**TO:** Nell Donaldson, Planner  
**FROM:** David Senus, PE  
**DATE:** February 3, 2016  
**RE:** 65 Munjoy Street, Final Level III Site Plan Application, Response to Comments

Woodard & Curran has reviewed the Response to Comments submittal for the Final Level III Site Plan Application for the proposed 8-unit condominium located at 65 Munjoy Street in Portland, Maine. The project involves the construction of an 8-unit condominium building to be constructed on an existing paved parking lot area.

RETAINING WALL DETAIL AT SPILLWAY TO RAIN GARDEN
NOT TO SCALE

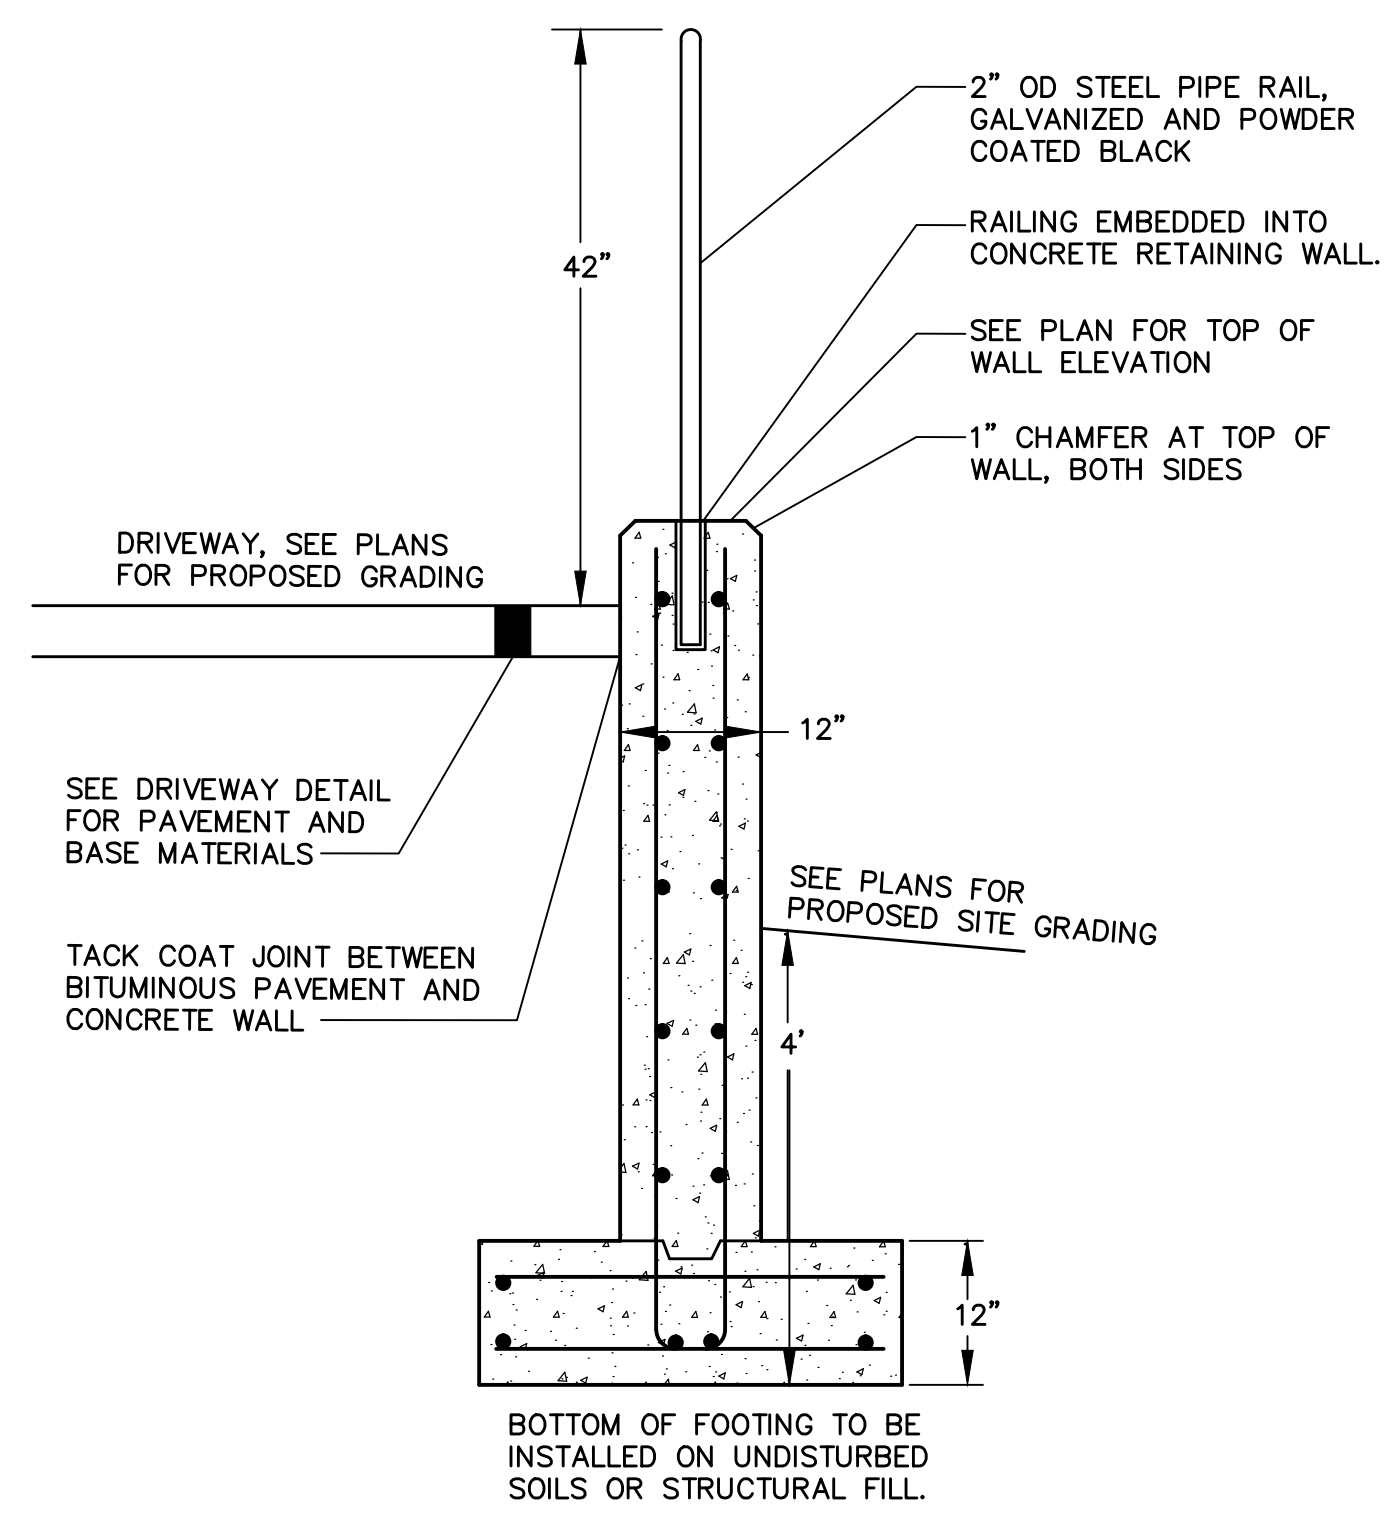
- b) General Standards: The project will result in a net decrease in impervious area of approximately 1,300 sq ft, as such, the project is not required to include stormwater management features for stormwater quality control. The Applicant has proposed to construct three rain gardens to capture and infiltrate stormwater runoff, along with a pervious paver patio area to infiltrate stormwater that falls onto the patio surface. We find this to be an acceptable approach for stormwater management for the site.

- c) Flooding Standard: The project will result in a net decrease in impervious area of approximately 1,300 sq ft, as such, the project is not required to include stormwater management features for stormwater quantity control. The Applicant has proposed to construct three rain gardens to capture and infiltrate stormwater runoff, along with a pervious paver patio area to infiltrate stormwater that falls onto the patio surface. These measures will help to further reduce runoff from the site; as such, we find the project to be in conformance with the Flooding Standard.
